Subject: Swauk Valley Ranch; PWS ID #AC733E; Kittitas County
New Group B Water System

From: [Samantha Cox](#)
To: [Elizabeth Schalo](#)
Cc: [Mark Brands](#); samw@apssm.com
Subject: RE: Swauk Creek Ranch flood needs
Date: Tuesday, June 3, 2025 8:30:24 AM
Attachments: [image001.png](#)
[image002.png](#)

Subject: RE: Swauk Creek Ranch flood needs

SWAUK VALLEY RANCH CONSERVATION PLAT

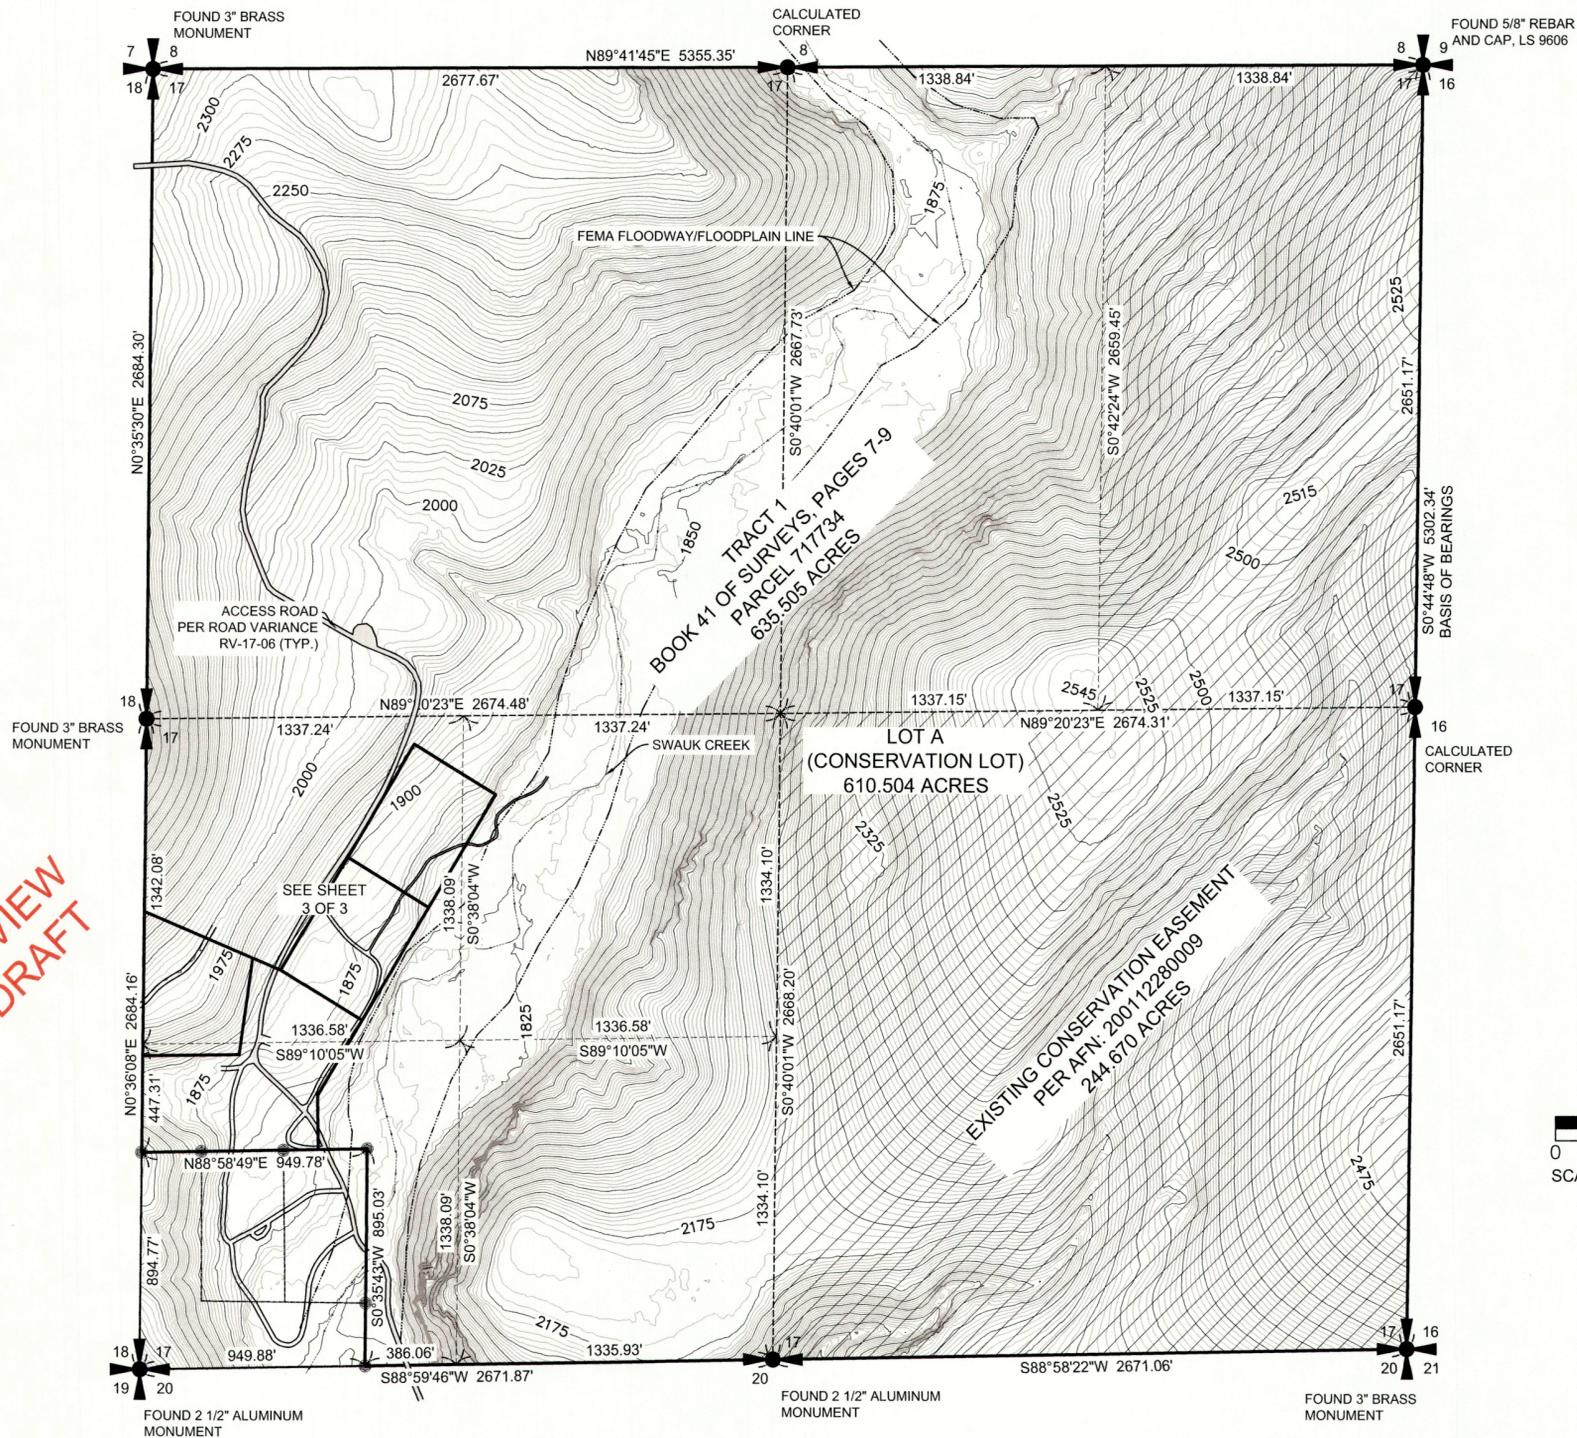
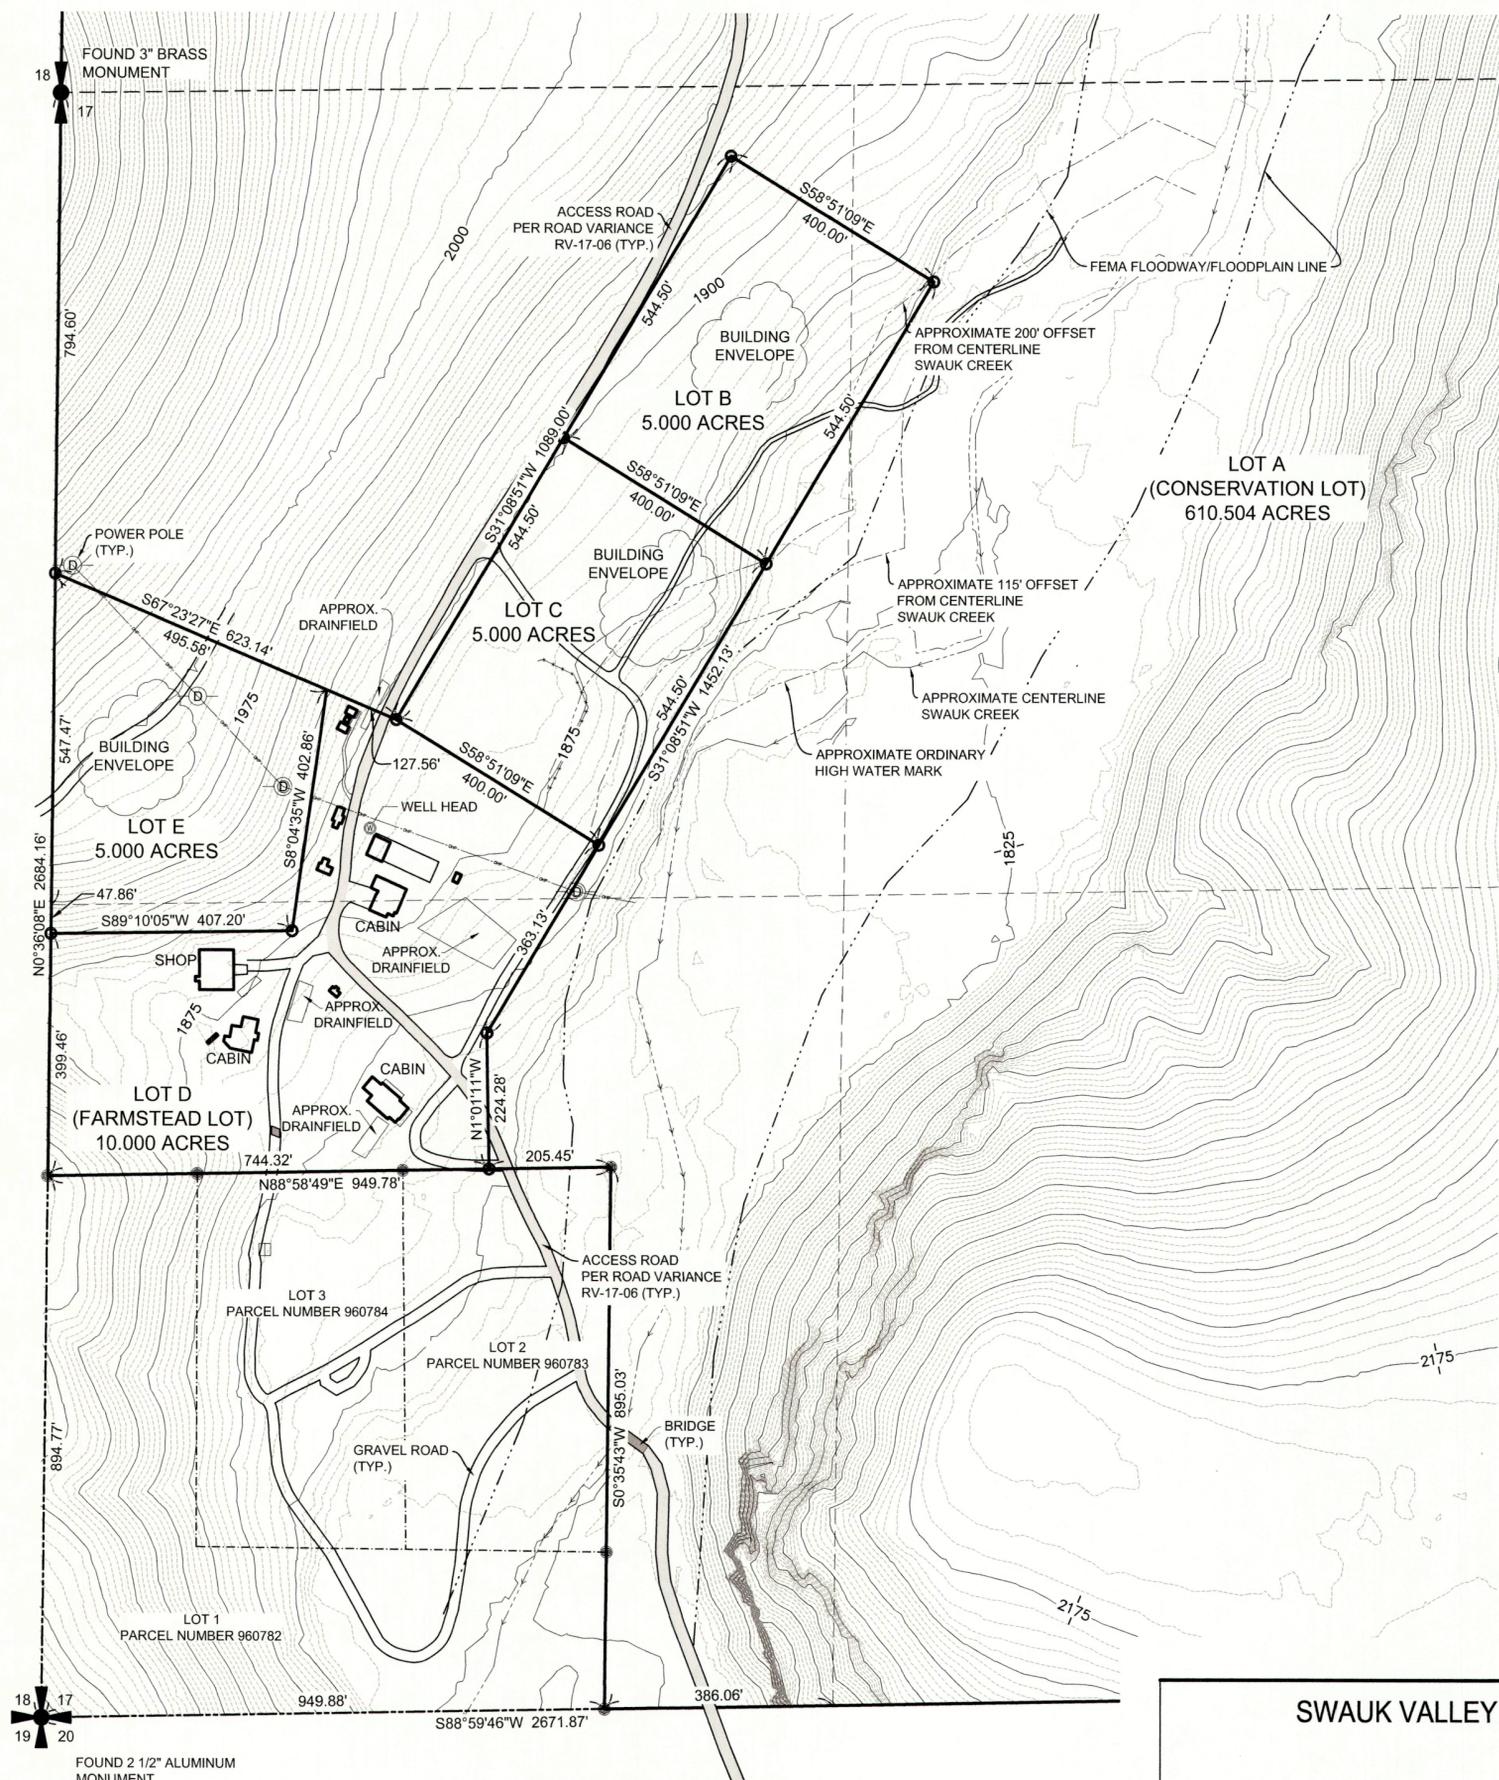
This sounds like a good plan. Please be sure to include the floodplain boundary on the preliminary plat map.

I was able to confirm with Ecology that BFEs would not be required if the floodplain is completely contained within the conservation lot.

A plat note will be needed that states something to the effect of "base flood elevation data for Swauk Creek must be generated prior to any future development of the conservation lot". I will be working with our Planning Department and County Surveyor on the specific language that will be used for the official plat note.

If the floodplain boundary extends to any parcel in the plat other than the conservation lot, then a detailed study of Swauk Creek will be required for BFE data.

Thank you again for confirming this with Ecology. We have confirmed that the floodplain is completely contained within the conservation lot. Sam, who is working on the plat

drawings and cc'd here, will include a note on the preliminary plat application. That way, the specific language of the note can be commented on and revised as needed early in the process. I've also cc'd Mark, who is leading the project.
